LOCAL IMPACT REPORT

Cleve Hill Solar Park DCO (PINS Reference EN010085)

Produced by Kent County Council (KCC)

June 2019

**Public Rights of Way
and NMU Survey Locations**
Figure 14.3

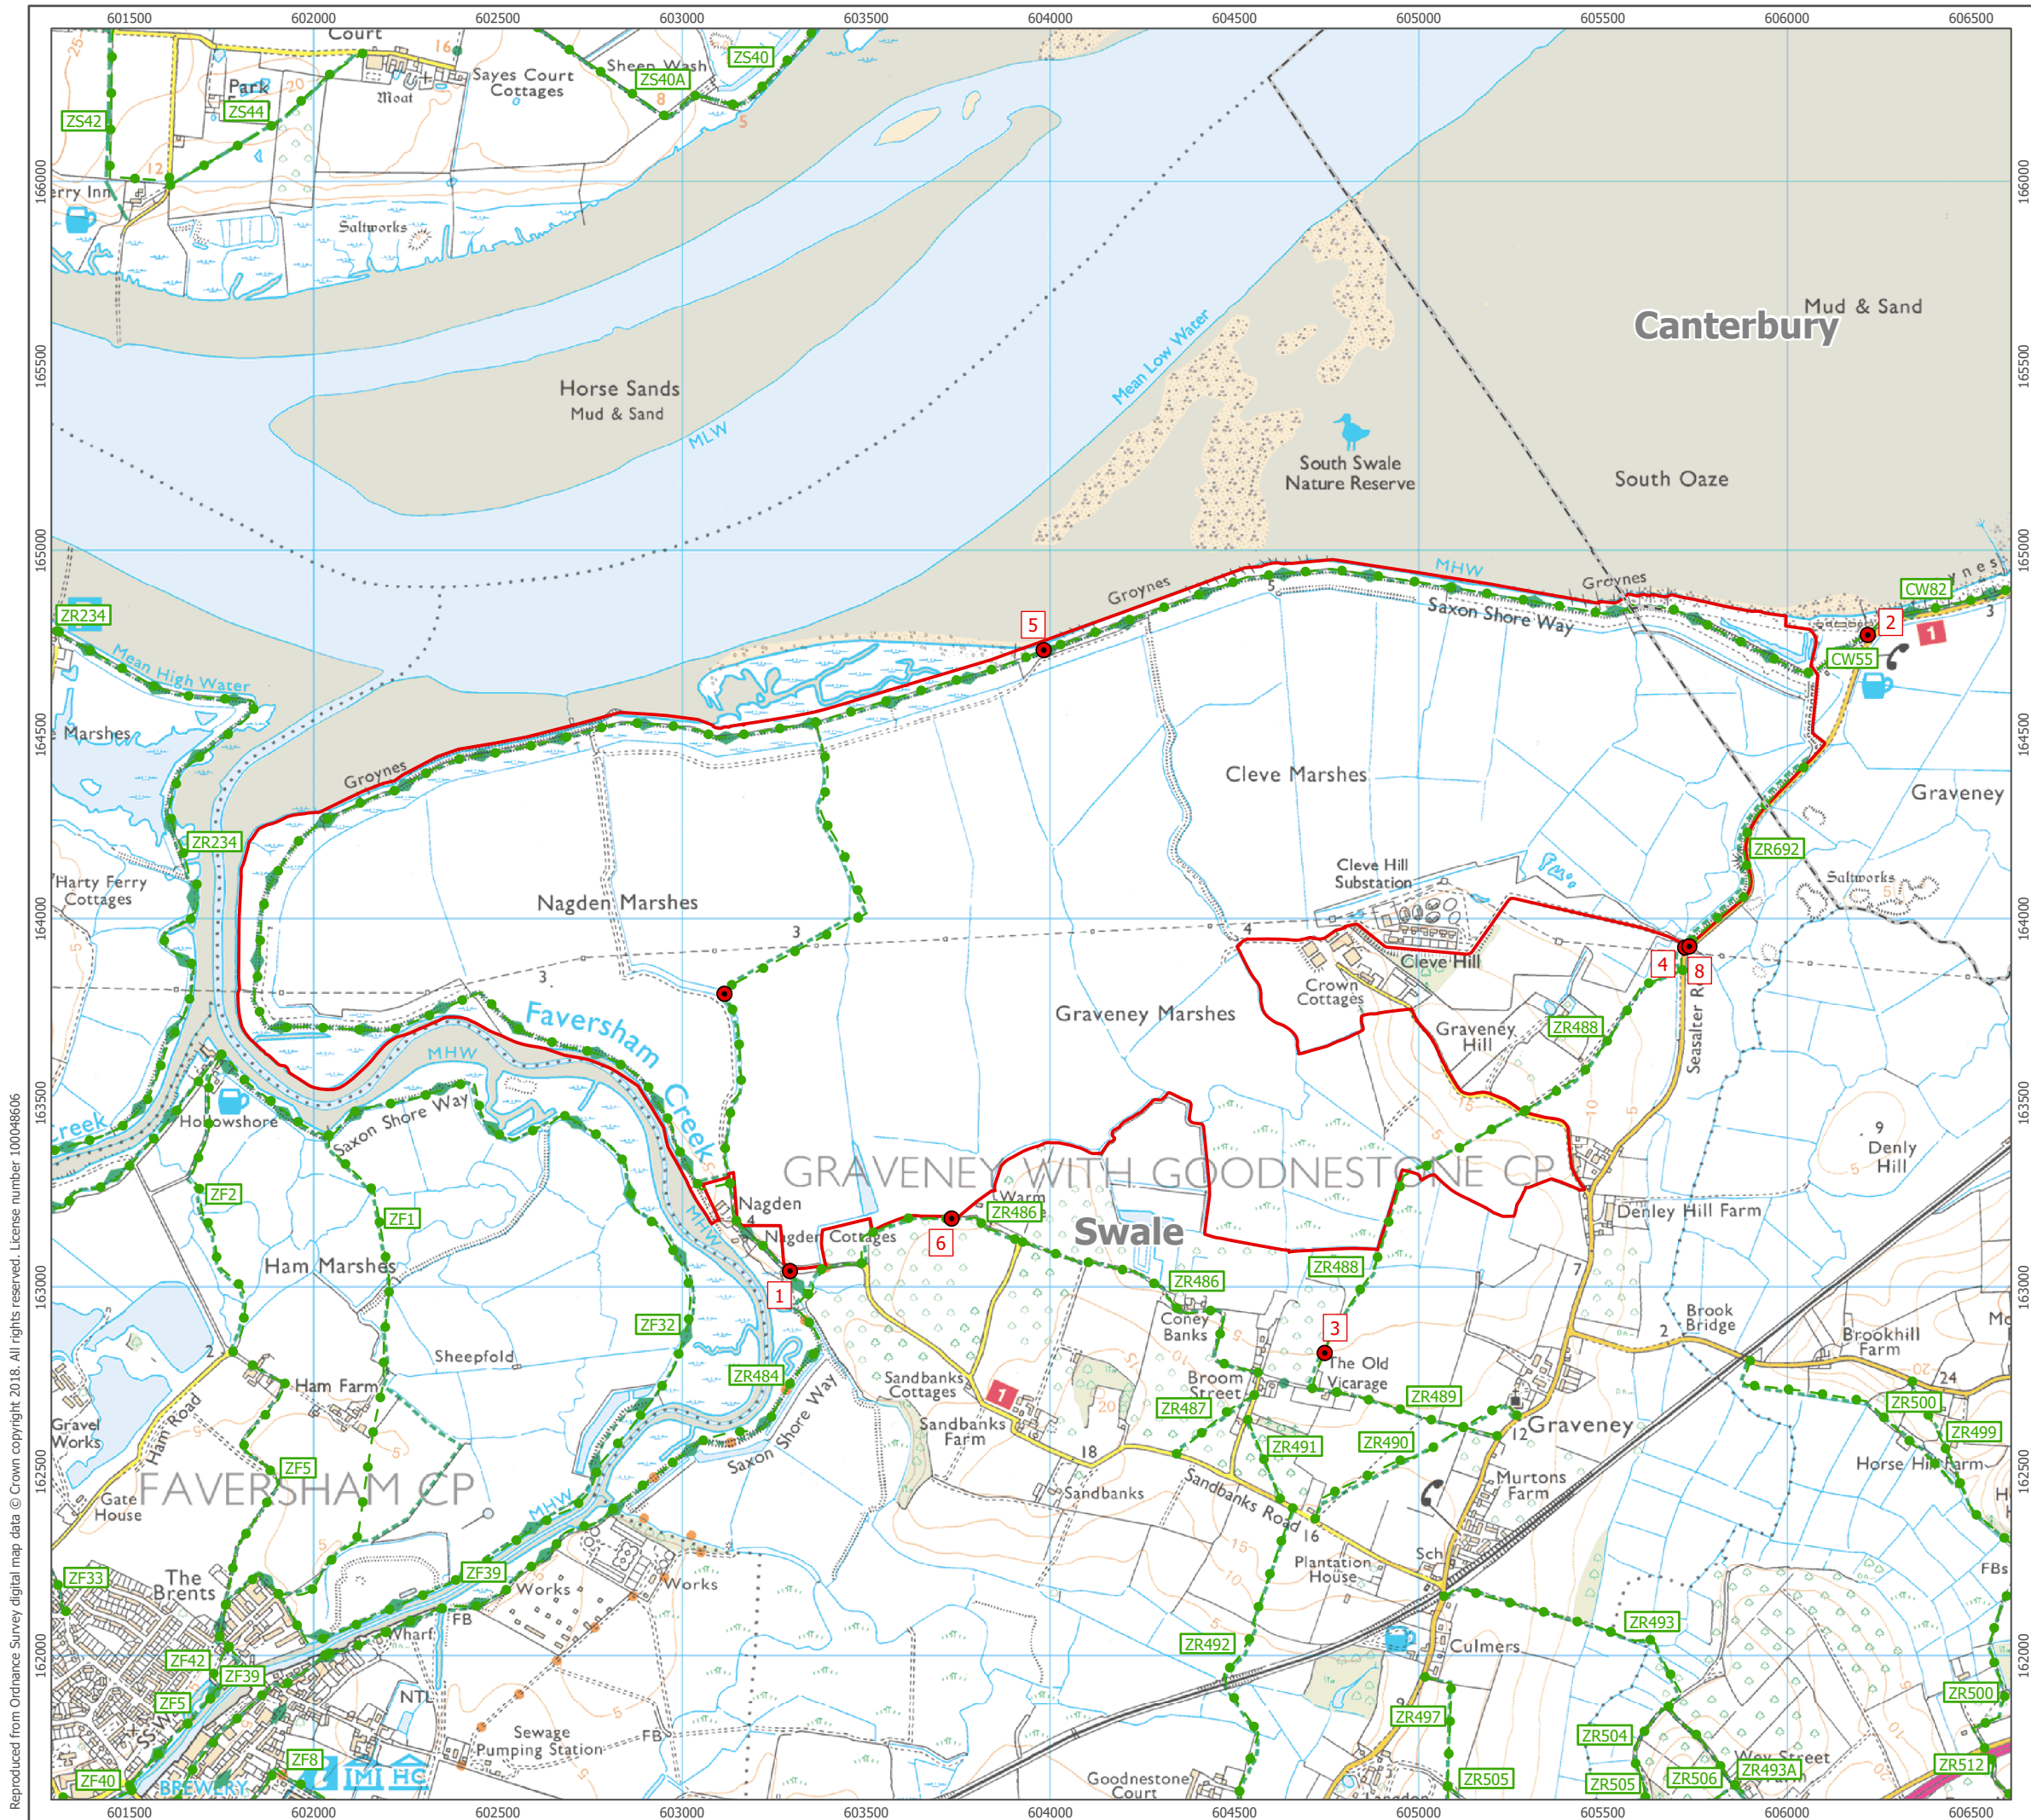
surveys. As the video surveys were only operating on four days, KCC disagrees with the applicant's view that data collected from their surveys is an accurate reflection of PRow usage. Caution must therefore be taken when referring to the results of the NMU Survey (Table 14.8), as the figures obtained during this limited study may not be truly reflective of actual path use.
